28th February 2024

S73 Application for Variations to Approved Plans Under Condition 2 of Appeal Decision Notice APP/C1625/W/22/3313131 (original application ref. S.22/1348/FUL) for Erection of 3 Bedroom Dwelling with Ancillary Site Improvements

Land at 1 Manor Farm House, School Lane, Whitminster, GL2 7NT

Sheet: M. Farm | P - 04 d

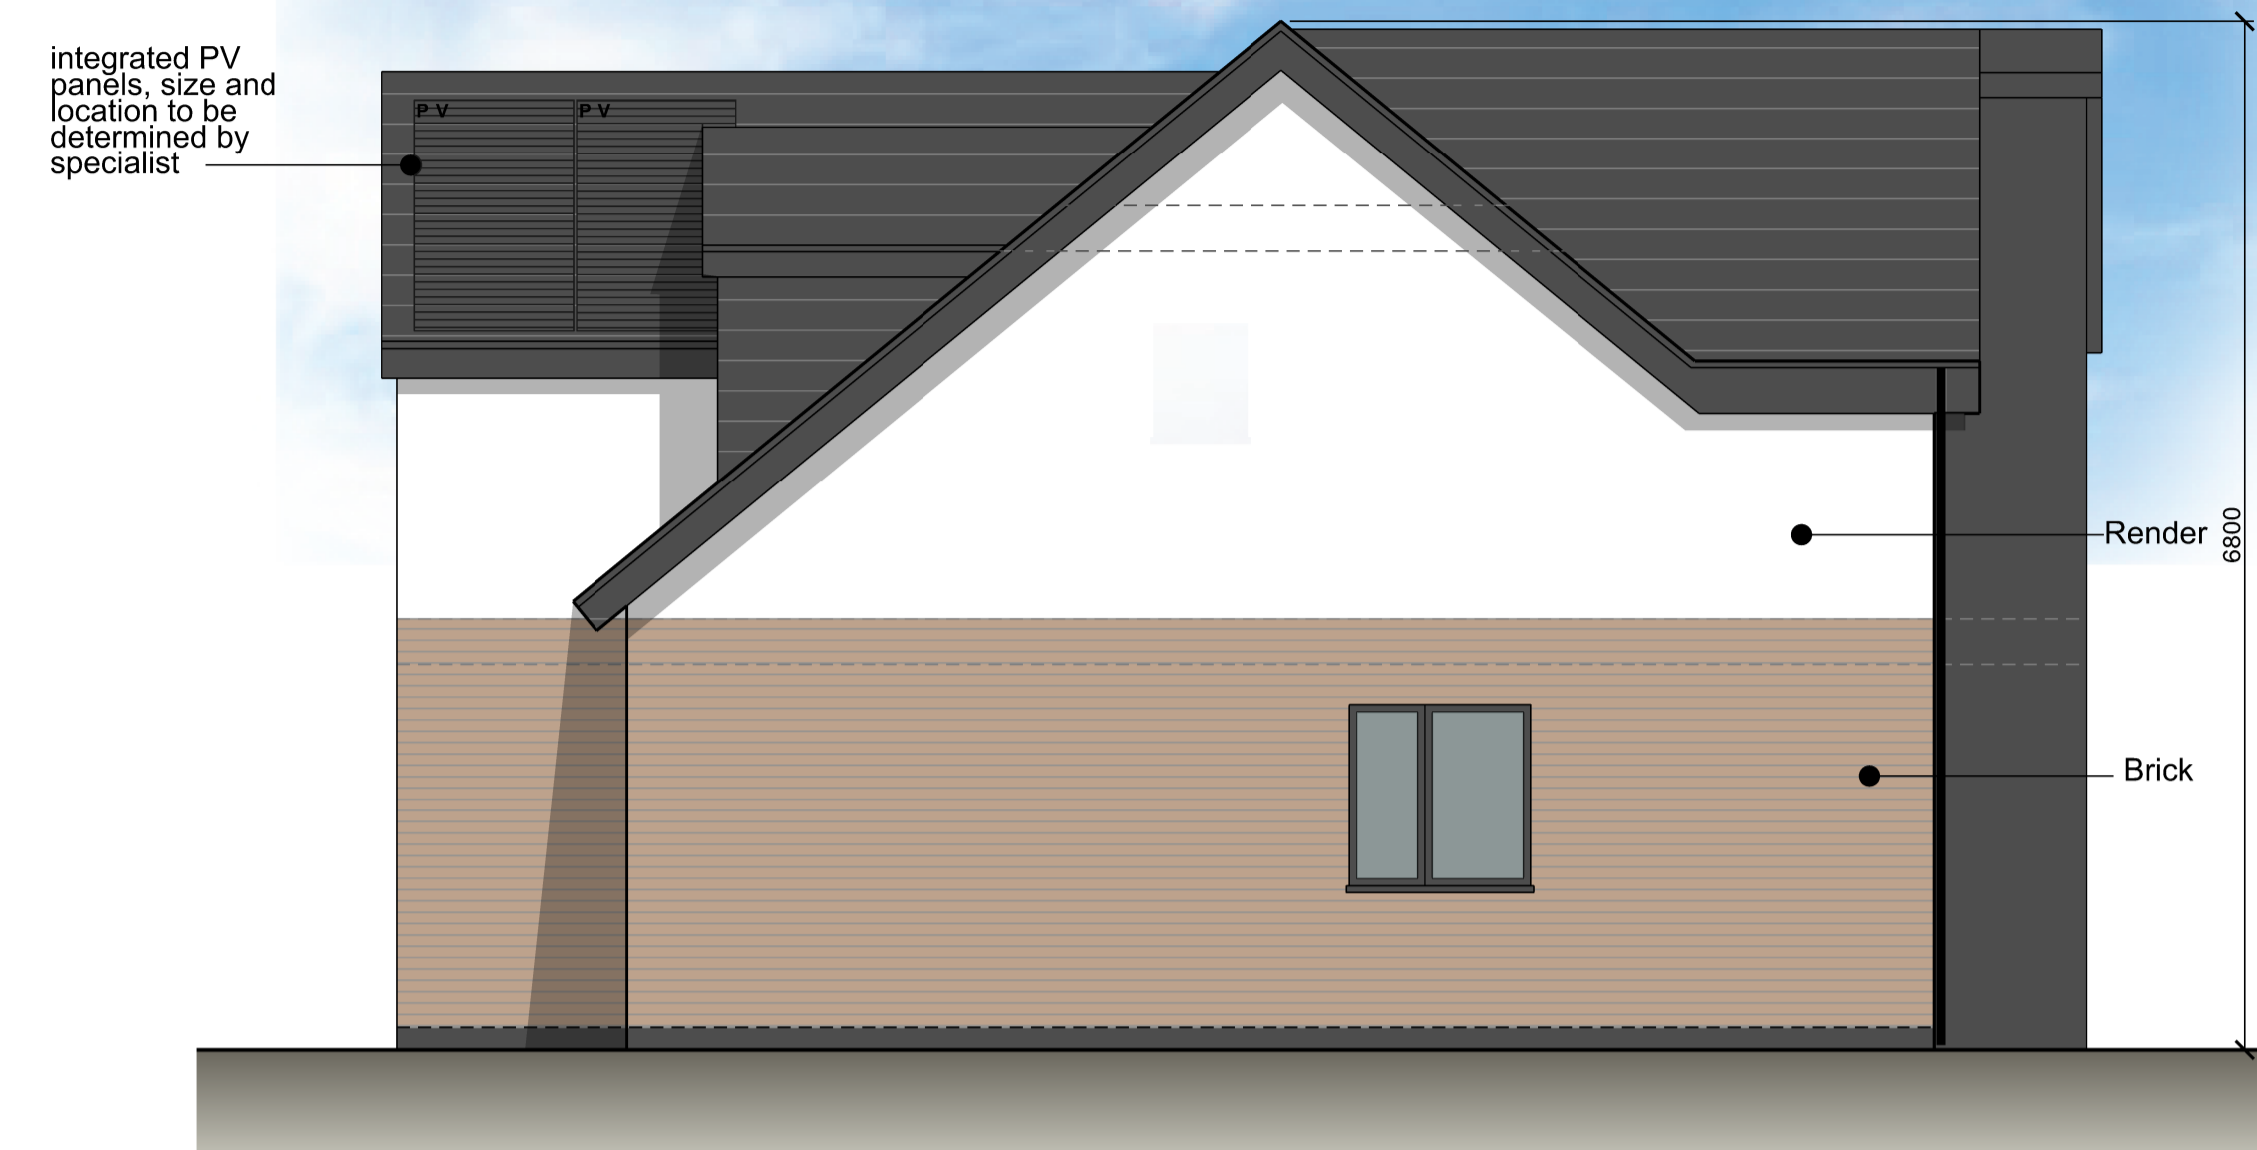
In summary, the proposed changes to the approved scheme include a mono-pitched roof over the study to provide better insulation and internal head height, a wider window opening to the left of the front door to facilitate an internal layout change, a wider matching bedroom window above for balanced aesthetics, additional PV panels to the rear for electric vehicle charging, and changes to the materials for the replacement garage to match the render of the new dwelling.

Item	Approved elevation / site plan	Proposed elevation / site plan
Floor plan and site section		
<p>Changes: Minor layout/floor plan modifications.</p>		
South elevation		
<p>Changes: Rearranged and potentially increased size and location of photovoltaic (PV) panels for car charging (exact design and specifications to be determined by a solar specialist).</p>		
North elevation		
<p>Changes:</p> <ul style="list-style-type: none"> • Replacement of flat roof above the study window with a mono-pitched roof to: <ul style="list-style-type: none"> ○ Improve insulation u-value for enhanced energy performance

- Increase internal head height
- Enhance external aesthetics
- Simplify construction
- Widening of window opening to the left of the front door with a clad block pillar between windows. This allows for an internal wall to be built, separating the WC from the utility area for improved functionality.

Change: Removal of the single door and its replacement with a small window featuring obscure glazing. Replacement with a new window design.

Change: No changes other than the previously mentioned mono-pitched roof.

PROPOSED GARAGE

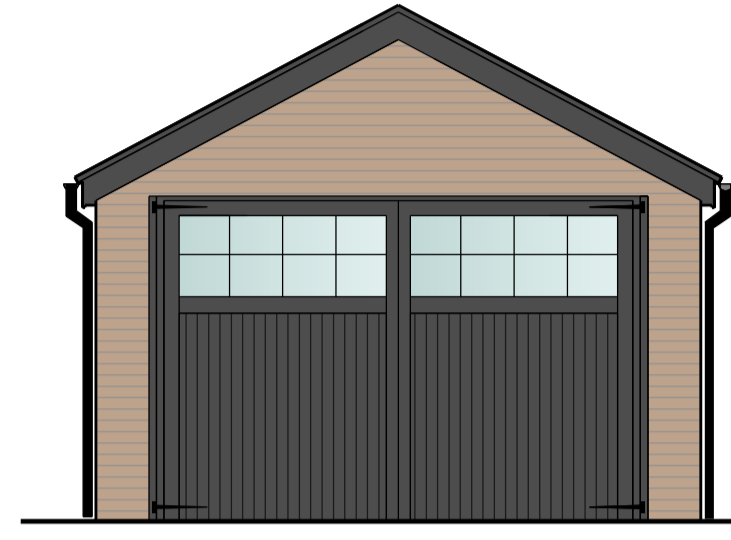
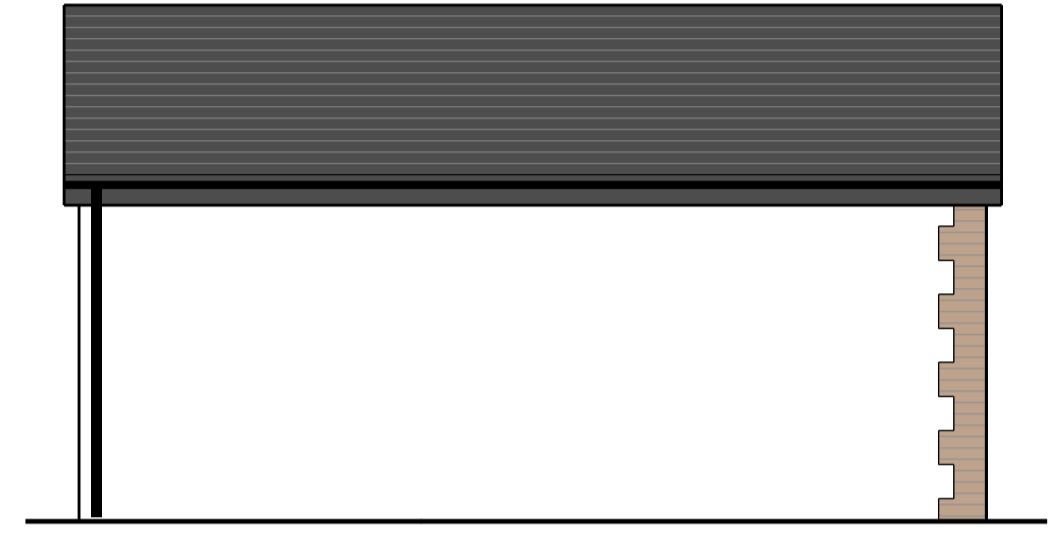
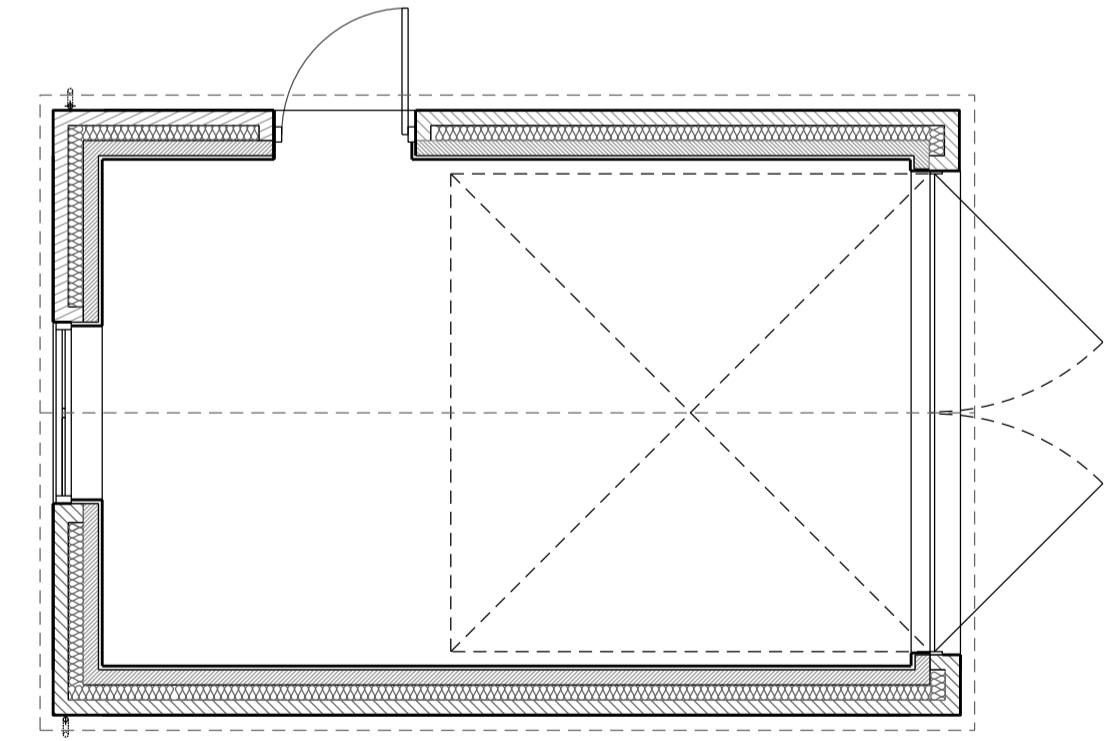
- Change:
- Conversion of the double garage doors to a single door located on the northwest side of the wall.
 - Change to materials for the replacement garage:
 - Front elevation retains the original, reclaimed bricks from the existing garage.

| | <ul style="list-style-type: none">○ Side and rear elevations utilise render that matches the new dwelling, creating a cohesive aesthetic and avoiding the introduction of new materials. |
